**Ingleburn Resource Recovery Facility (SSD-8593)
Request for Additional Information**

I refer to the revised Response to Submissions (RTS), dated October 2020, for the Ingleburn Resource Recovery Facility (SSD-8593).

Attachment 1
SSD 8593- Ingleburn Resource Recovery Facility
Review of Revised Response to Submissions dated October 2020

VEHICLE TURNING PATH
TRUCK & DOG: INTERNAL DROP OFF

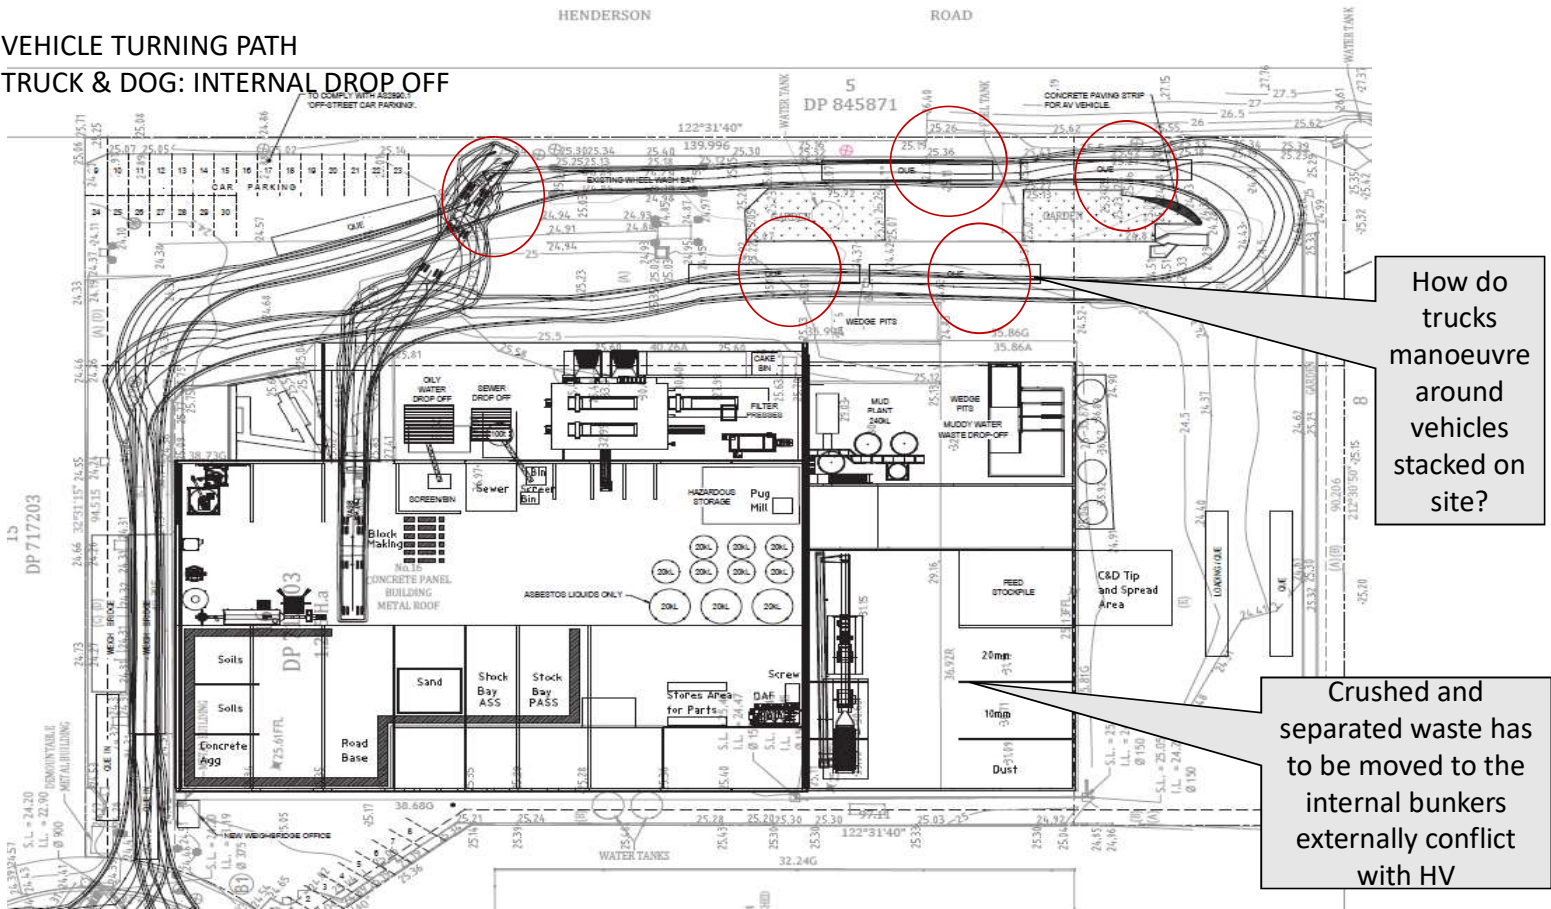
- Please provide a series of swept path analyses that:
 - demonstrates a vehicle can access the internal tip and spread area
 - demonstrates a heavy vehicle can navigate the awning support structures
 - shows two liquid waste vehicles operating internally.
- Drawing No. TURN02 in Appendix E indicates heavy vehicles would scrape against the existing noise barrier, please clarify.
- The May 2020 traffic assessment states that Lancaster Street would be used in lieu of on-site stacking yet the recent version of the RTS states that there would be no stacking or queuing. Please clarify how the facility would avoid stacking while accepting greater traffic volumes than the current development.

VEHICLE TURNING PATH
TRUCK & DOG: C & D TIP & SPREAD

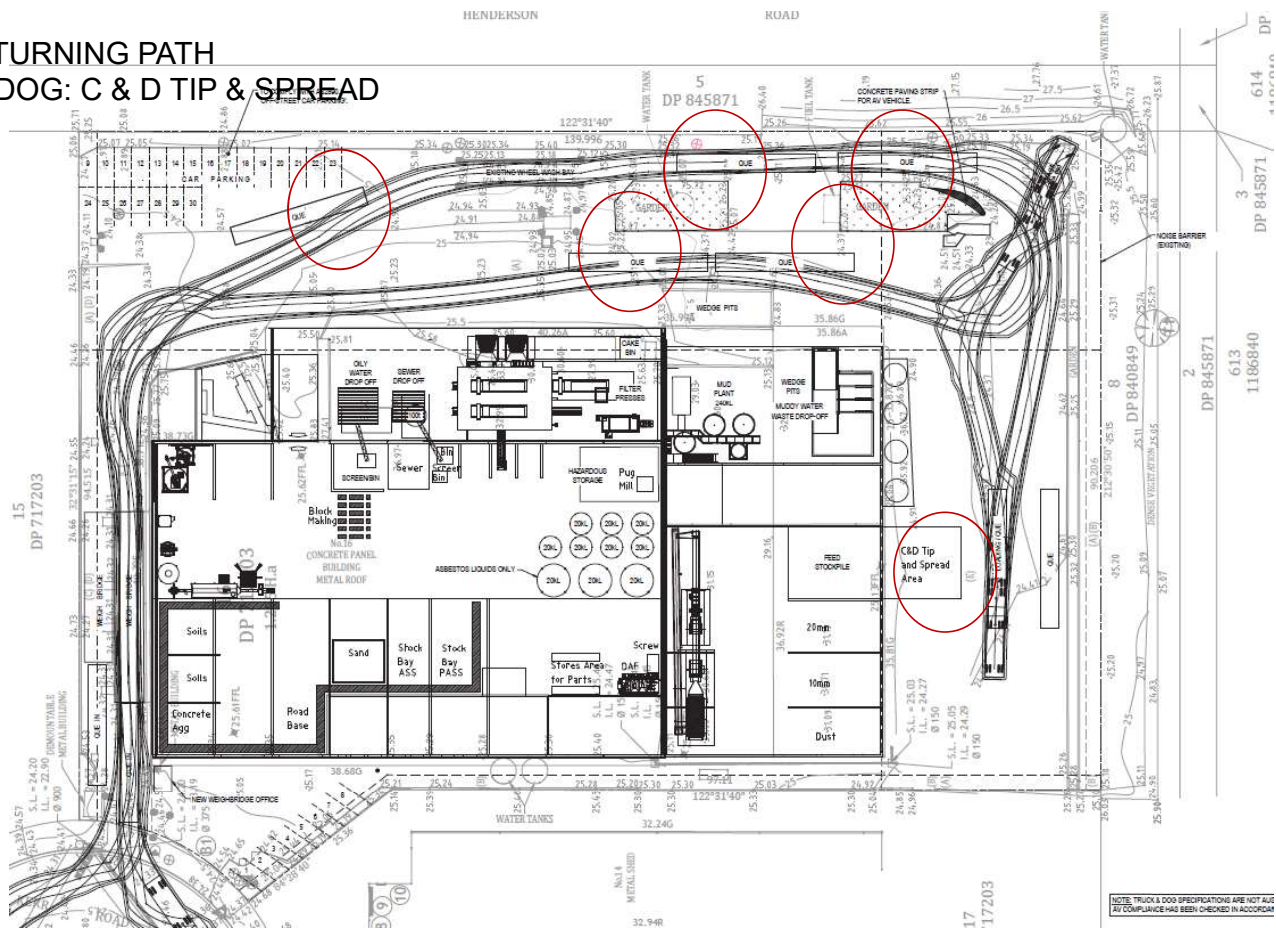
- Please demonstrate the tip and spread area is separate to the unprocessed C&D waste stockpile.
- Figure 15-1 provides the locations, names, dimensions and capacities of waste storage facilities. Please describe what would be stored in SB 4 - 6 and SB 19.
